Dear Nell:

Thank you for the opportunity to summarize some of the concerns I have been discussing with you over the past several months for presentation to the Planning Board.

I am disappointed that I am not able to attend the October 25th hearing. Thus, I offer the following additional thoughts:

**SITE PLAN**

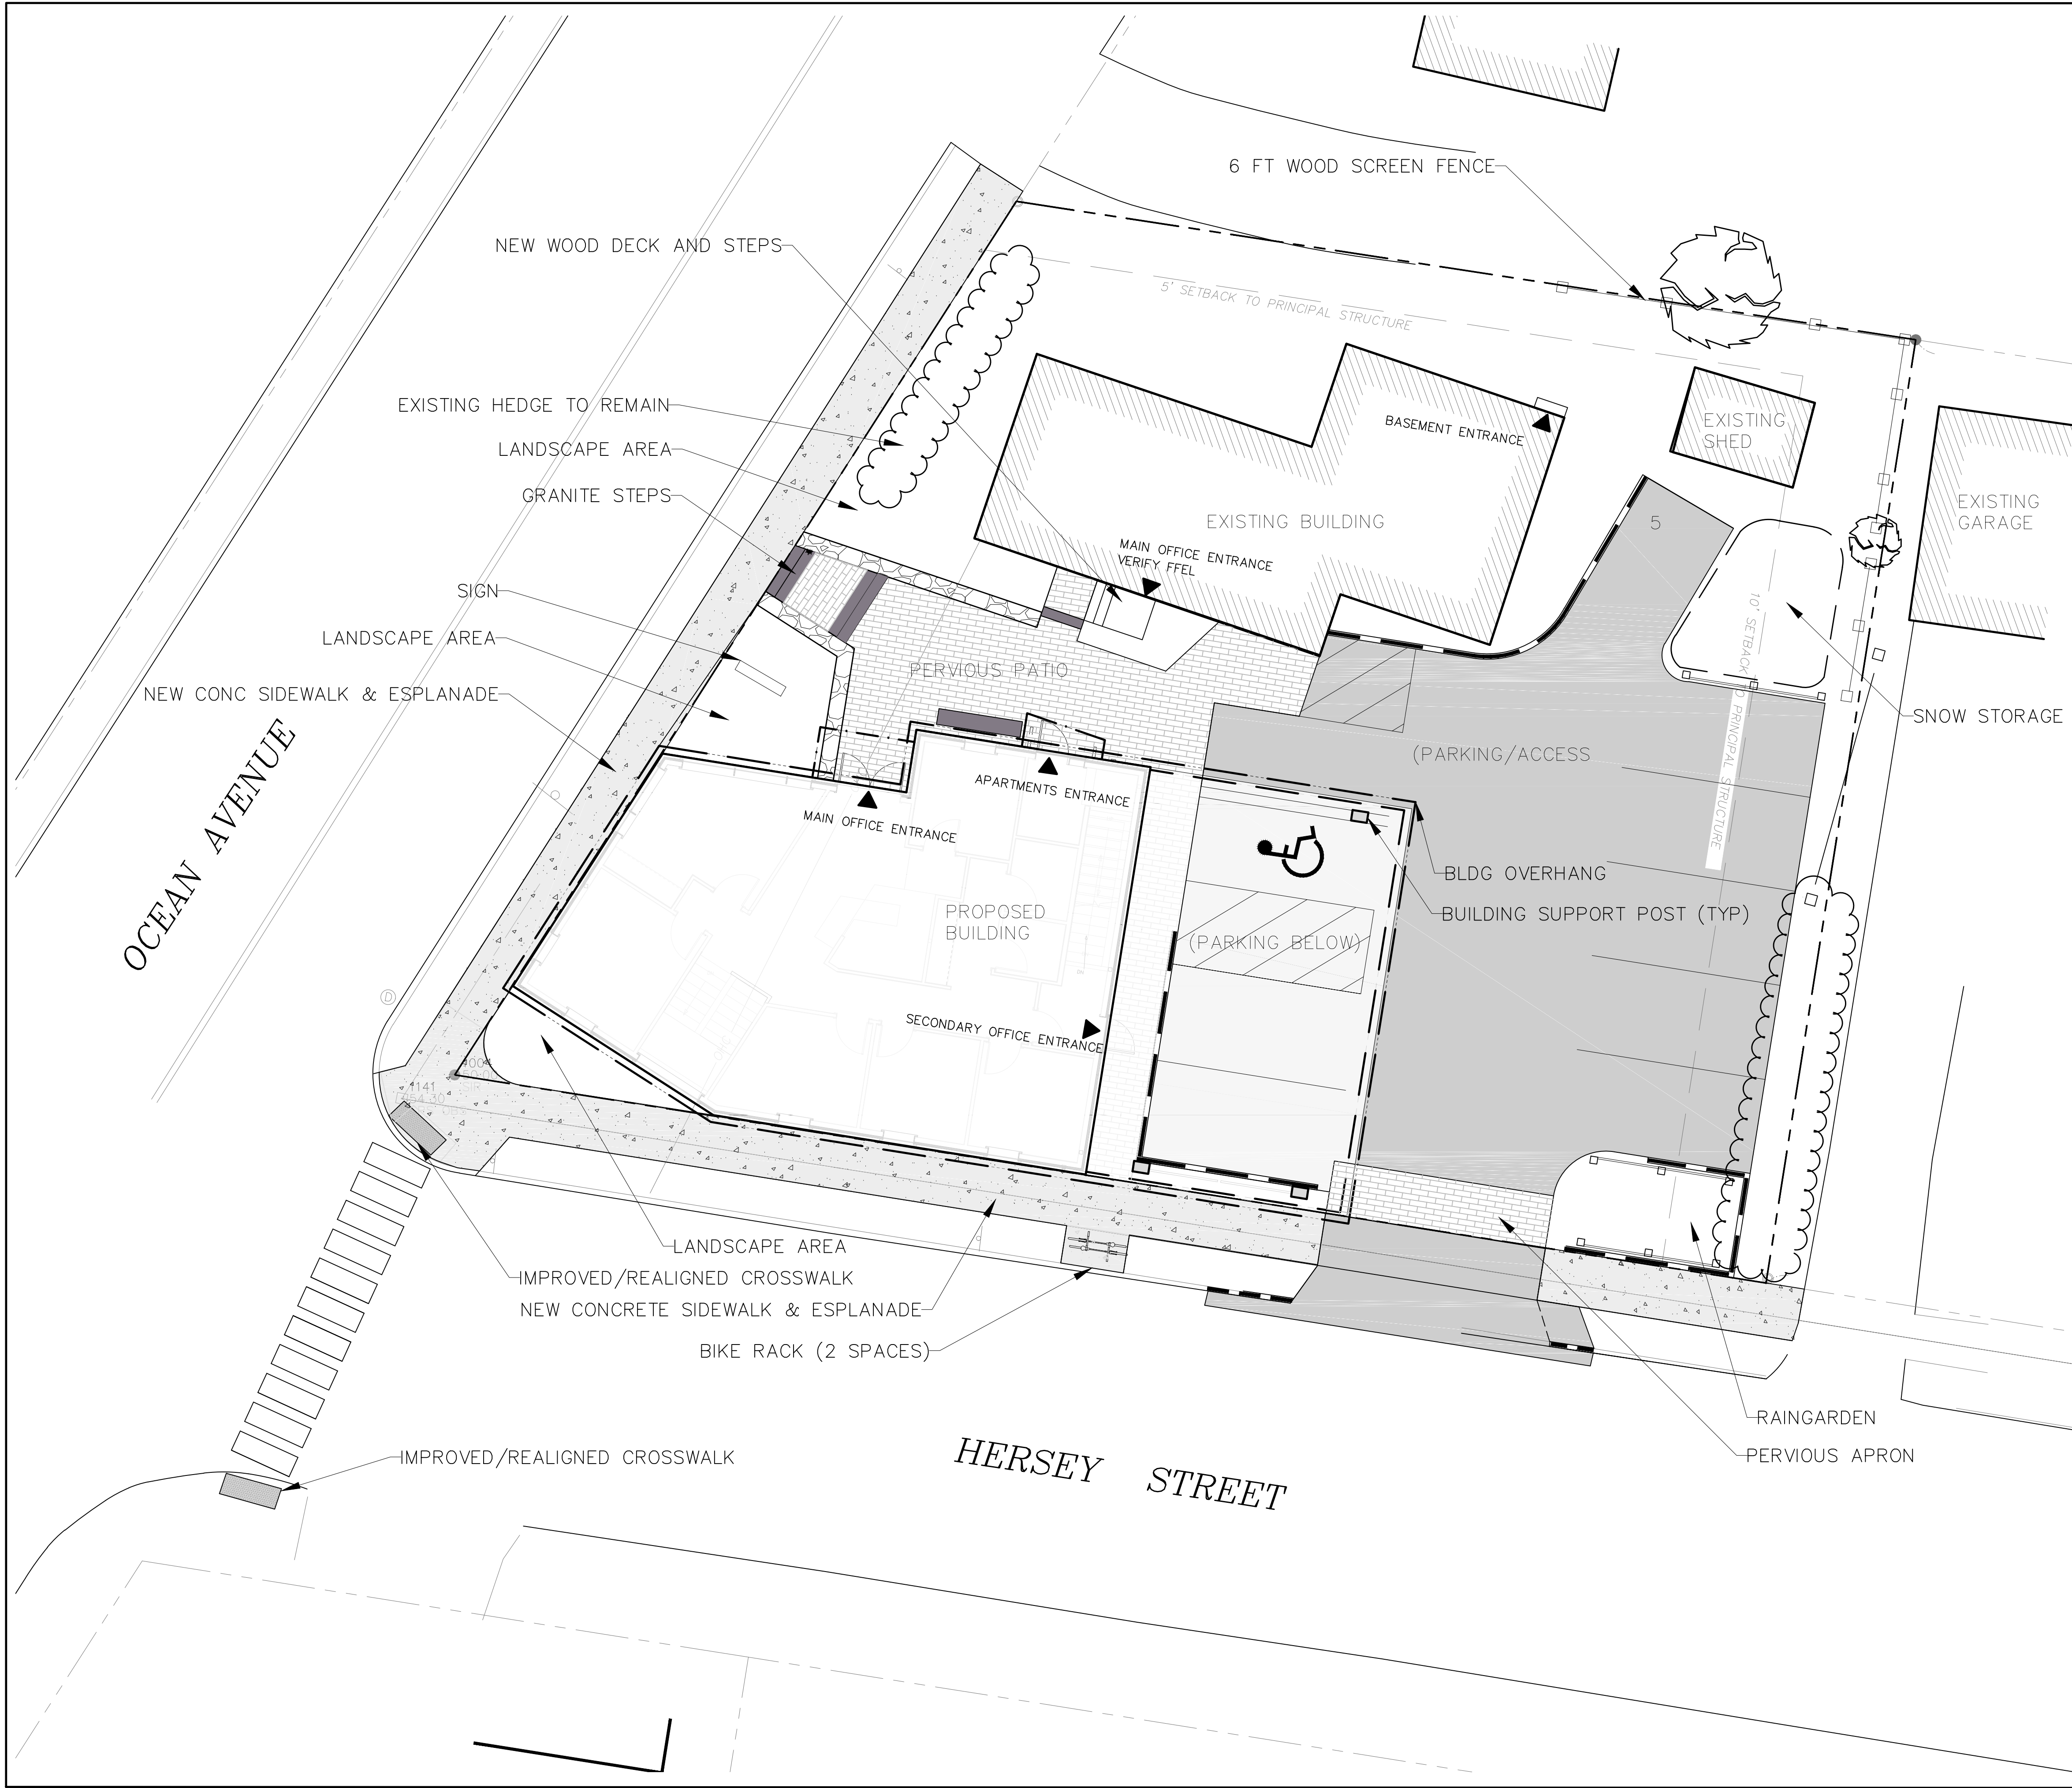
10. Given the constraints of the site, the **requested waiver for aisle width should NOT be granted.**
11. From **"Comment #3 of the memo, dated September 6, 2016 from Pat Carroll: "NOTE THAT THERE MAY BE NEIGHBORHOOD CONCERNS ABOUT SPILLOVER PARKING ON HERSEY STREET". THERE IS THAT CONCERN FOR SURE --GRAVE CONCERN. The applicant has not provided any analysis of the current ongoing on street parking problem on that end of Hersey Street. This analysis is critical and should be factored into a substantiated traffic and parking analysis (and on-street parking violations), with actual counts.**

13. Will there be any **blasting** required for construction?
14. **SNOW STORAGE.** Applicant should be required to haul snow off site. Any piled up snow will create loss of parking spaces and, thus, spillover parking on Hersey Street. Also, the stormwater features, rain gardens, etc., cannot be used for snow storage.
